# Storm Construction Plan Redlines.pdf Markup Summary

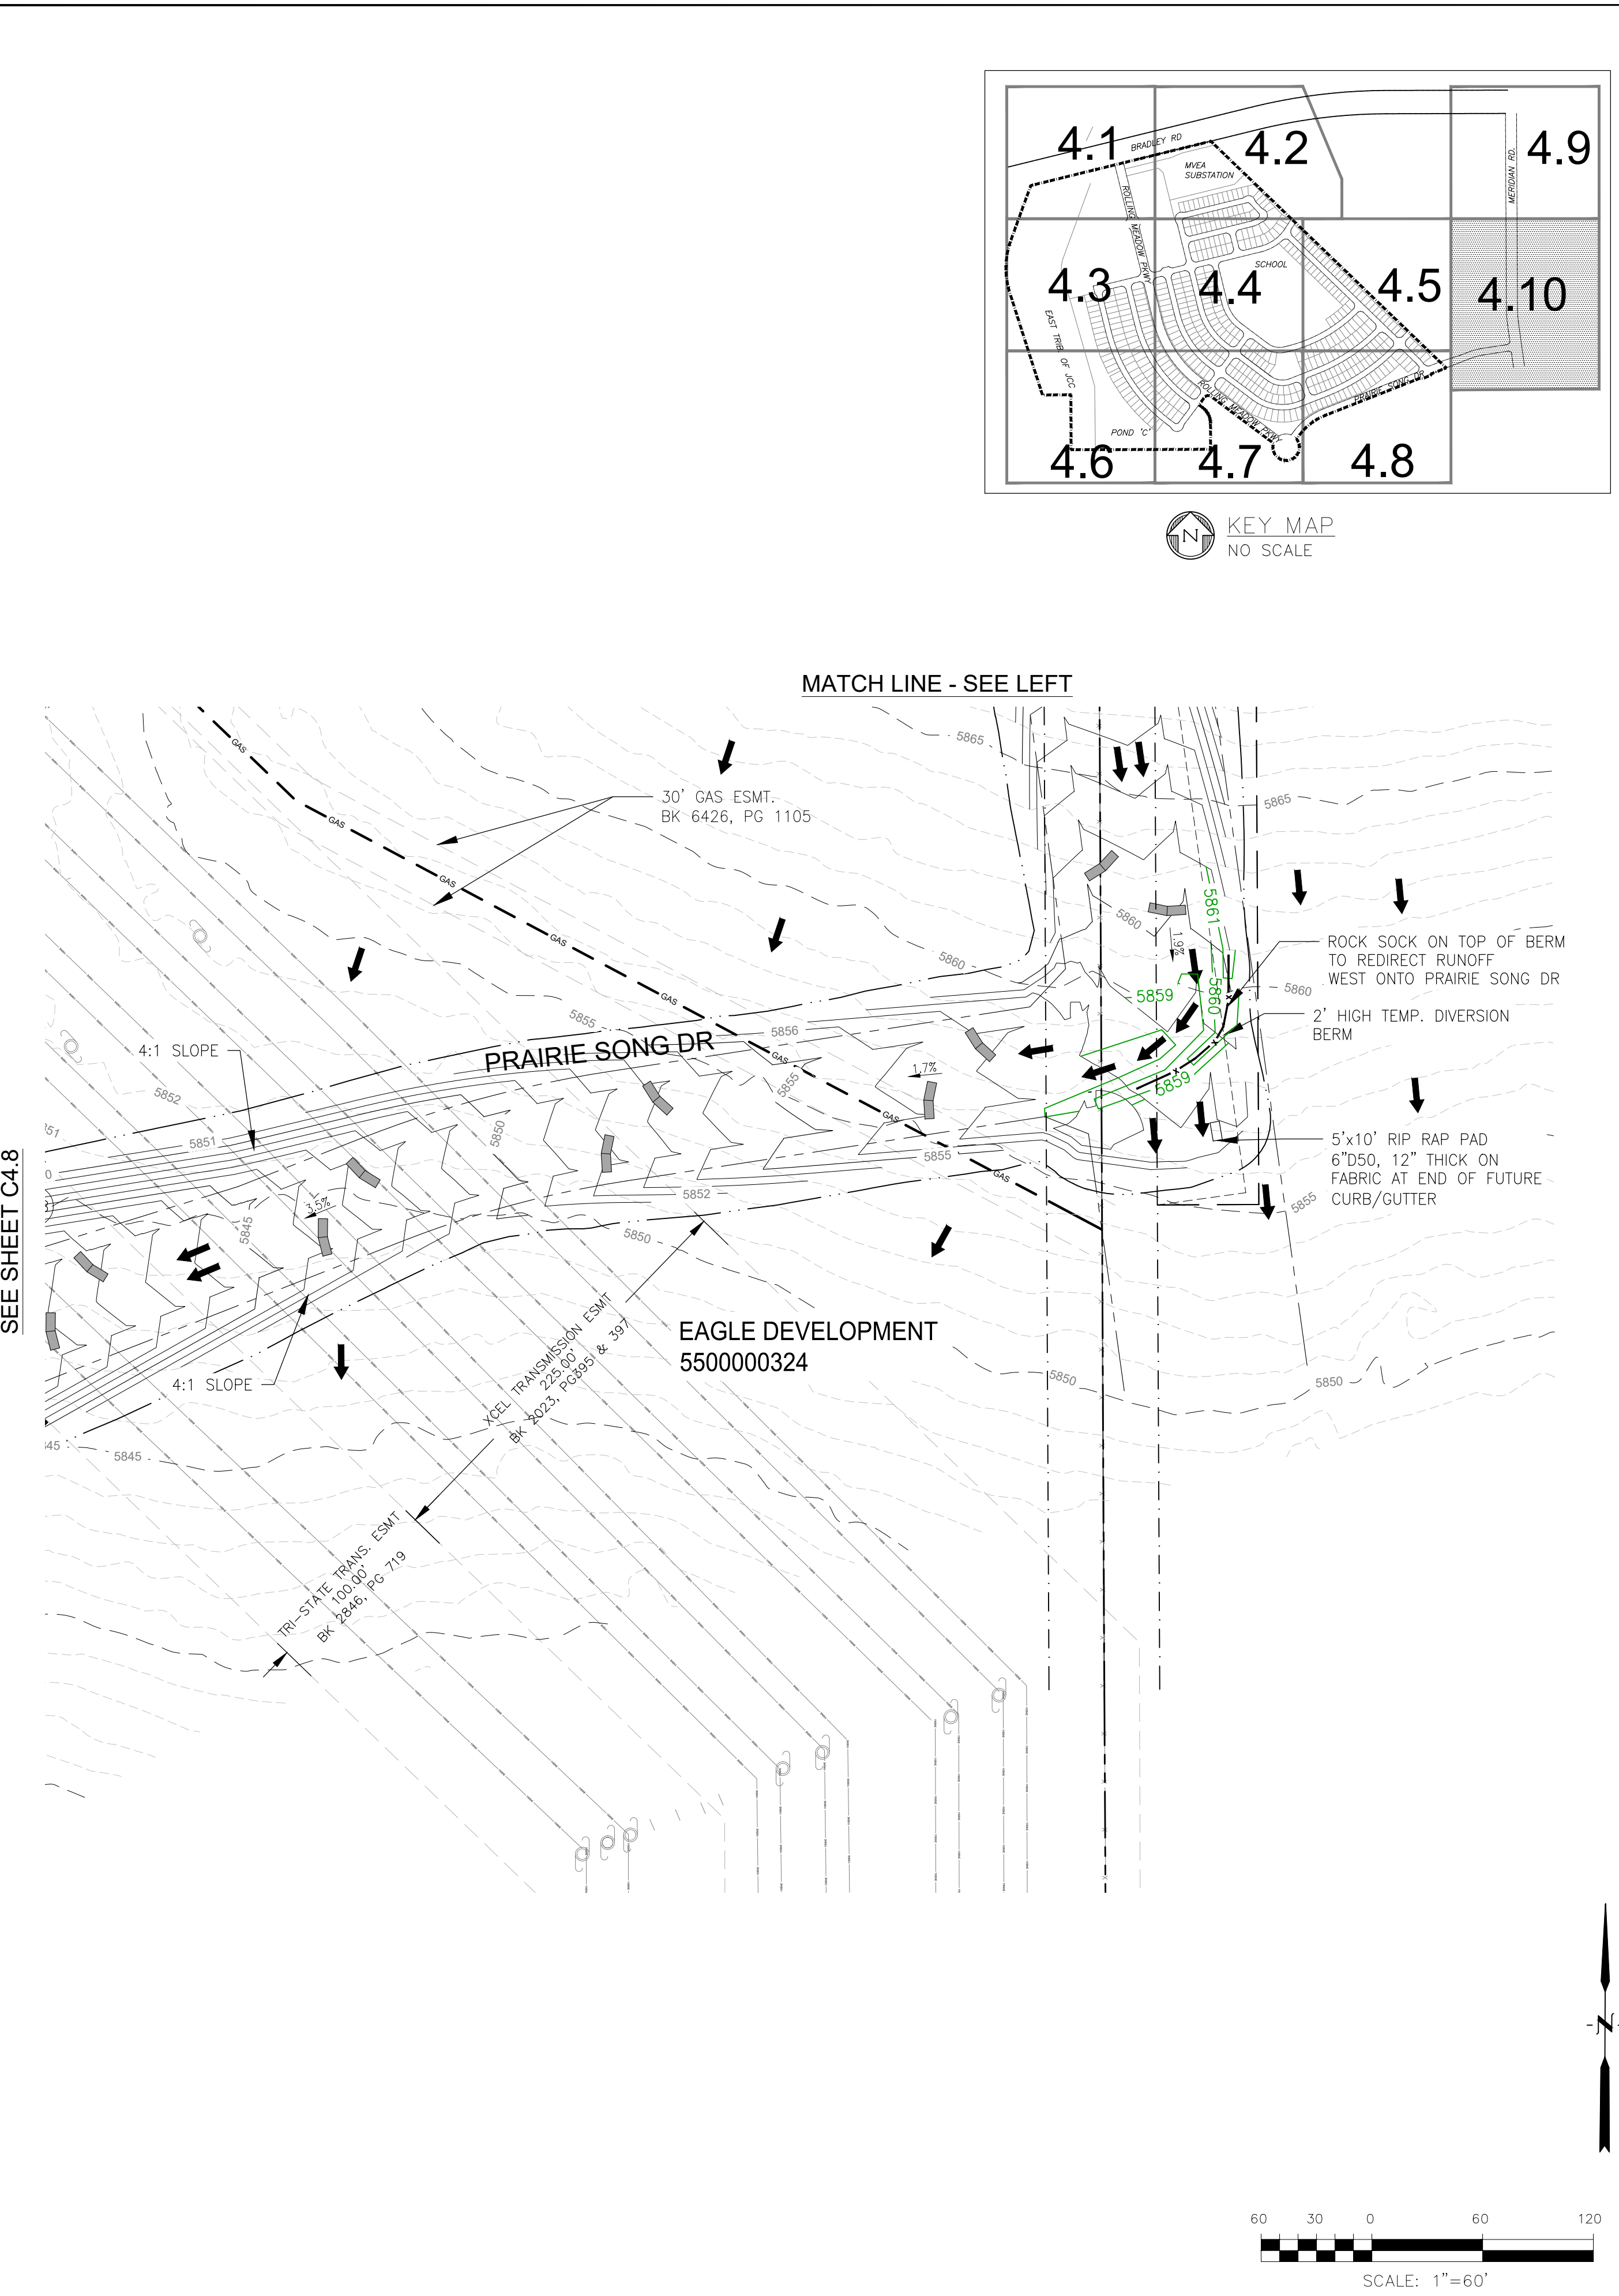
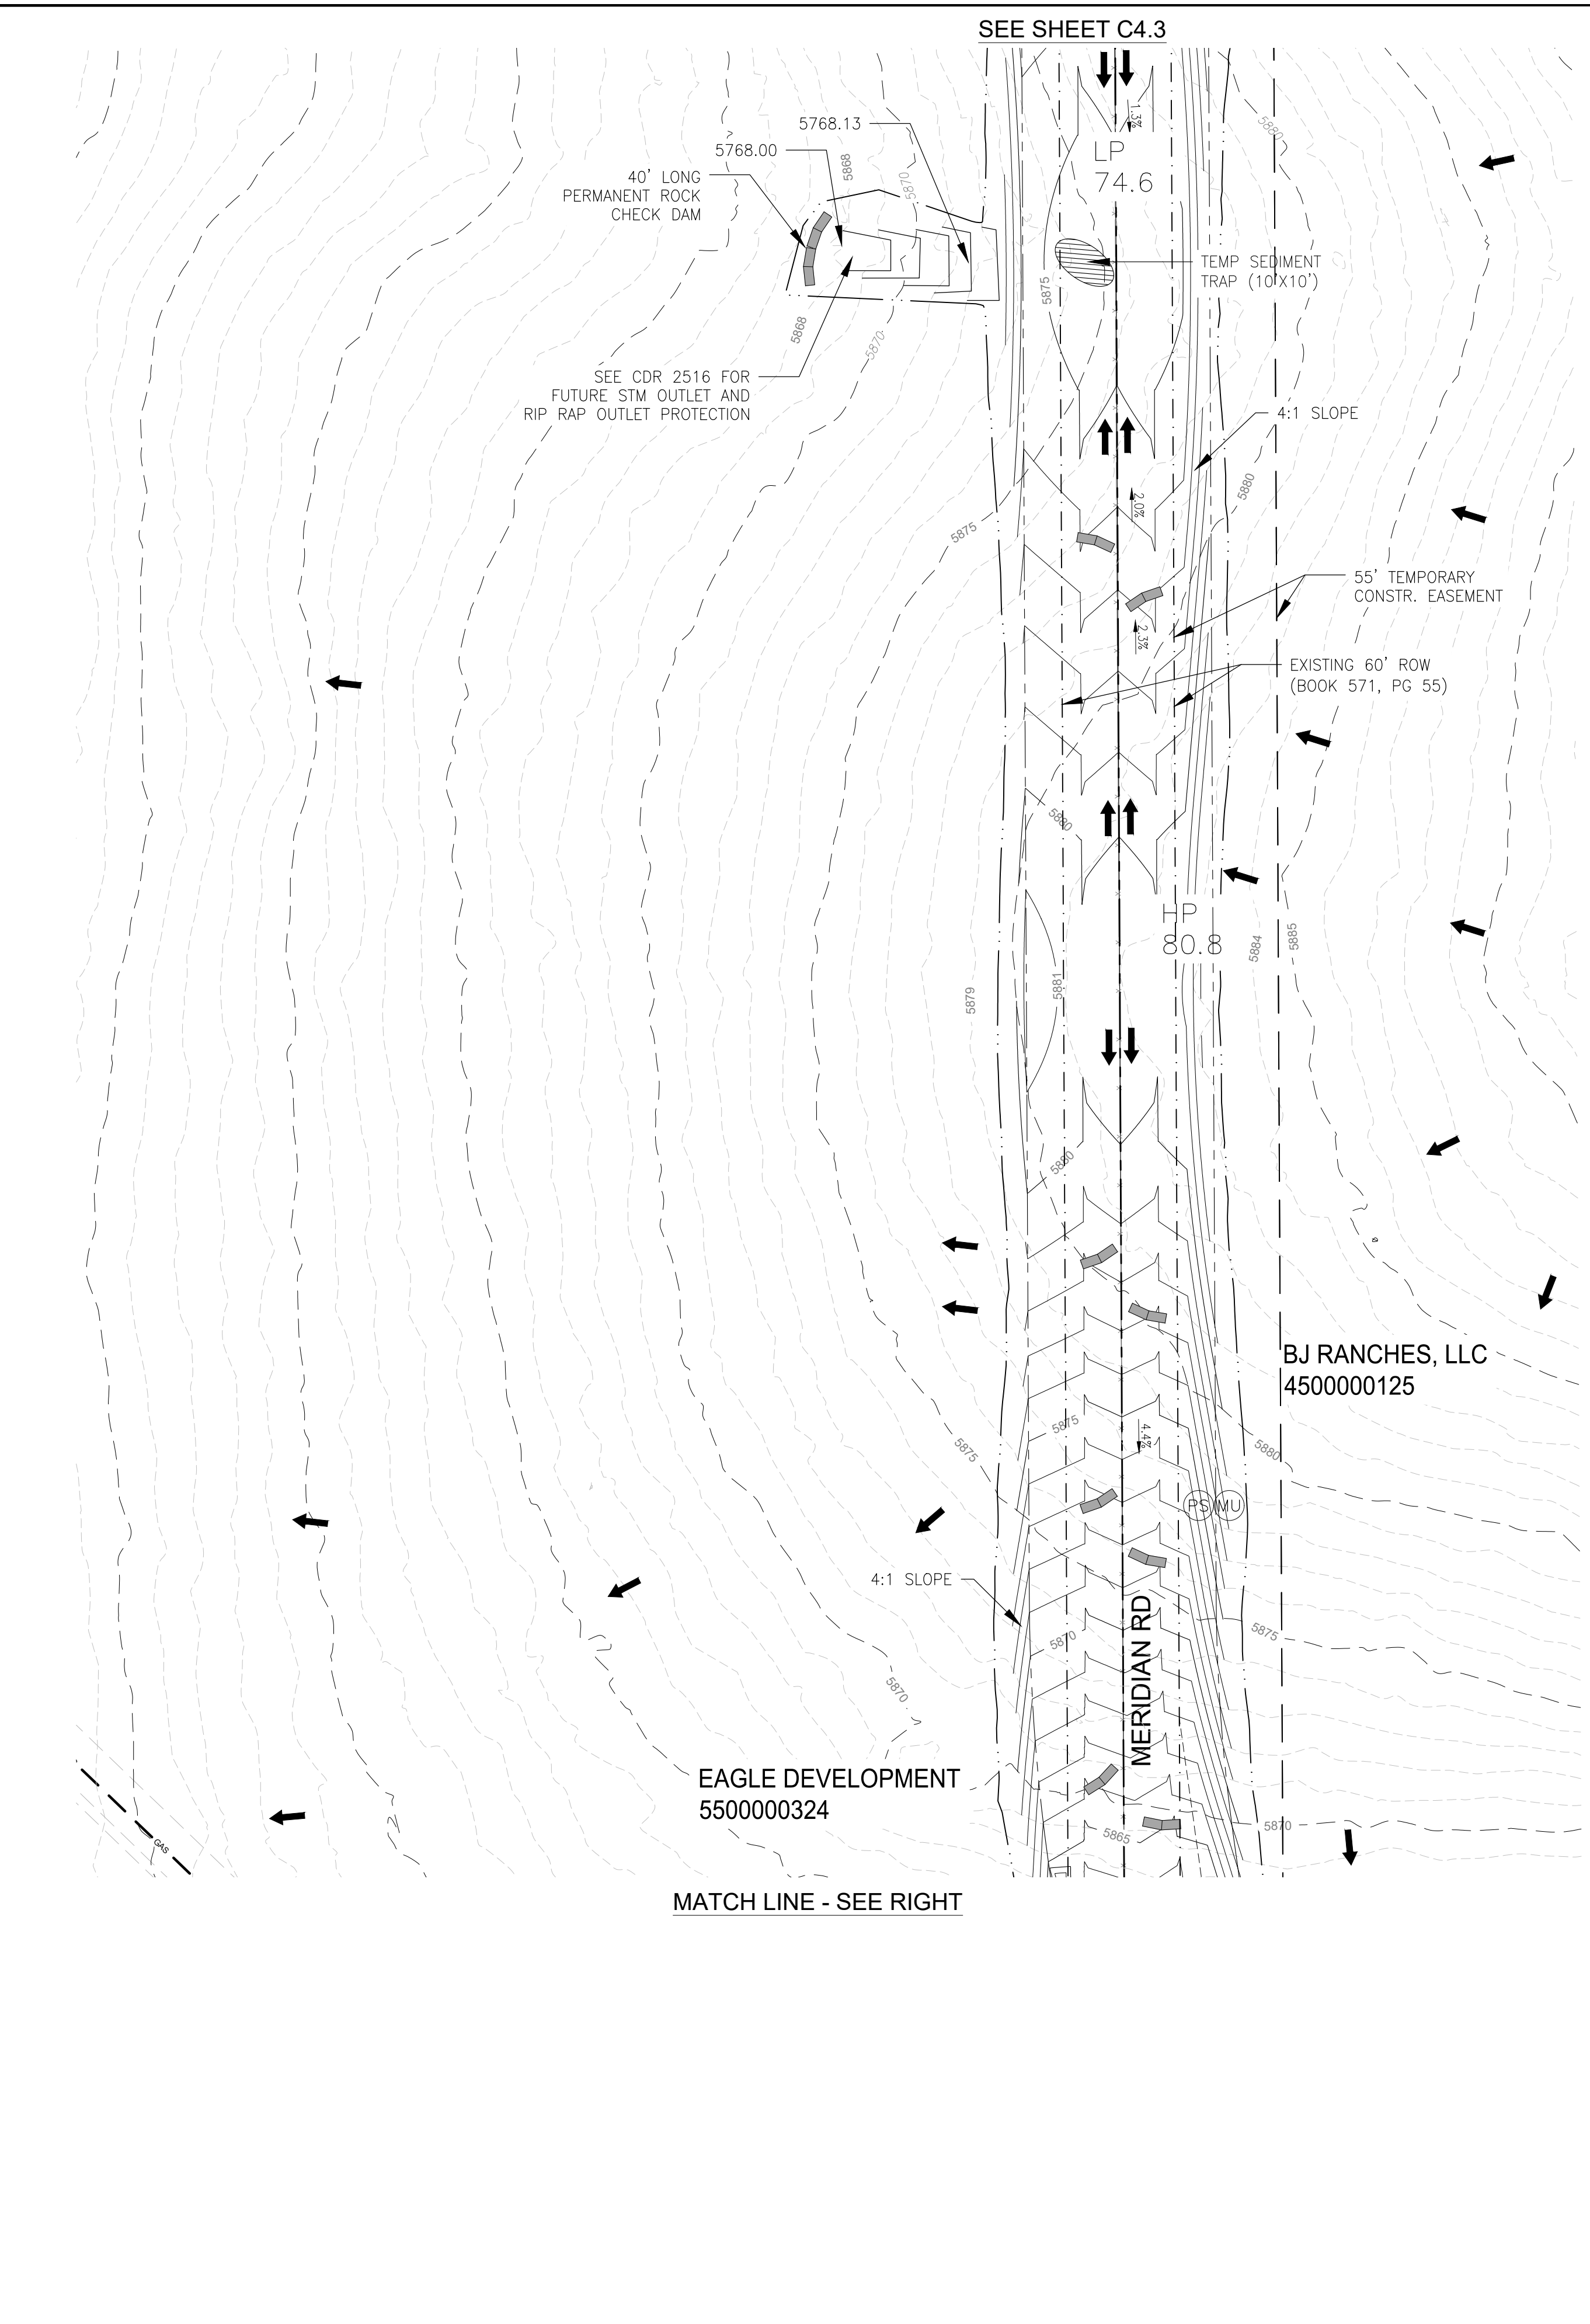
Easement Agreement / document number 217152003; show all easements as it relates to this project on all plans, provide width and label them. Typical comment to all plan sets

Please provide a whole sheet for the entire storm sewer system and show all storm sewer easements on it, make sure they are labeled and indicate the width of each storm sewer easement (It is hard to follow the individual segments).

AN OVERALL STORM SEWER SHEET IS ADDED. THE OVERALL SHEET SHOWS ALL EXISTING EASEMENTS AND ALL PROPOSED EASEMENTS/WIDTHS. MOST OF THE STORM SEWER IS IN TRACTS WHICH THE ENTIRE TRACT IS A DRAINAGE/UTILITY EASEMENT.
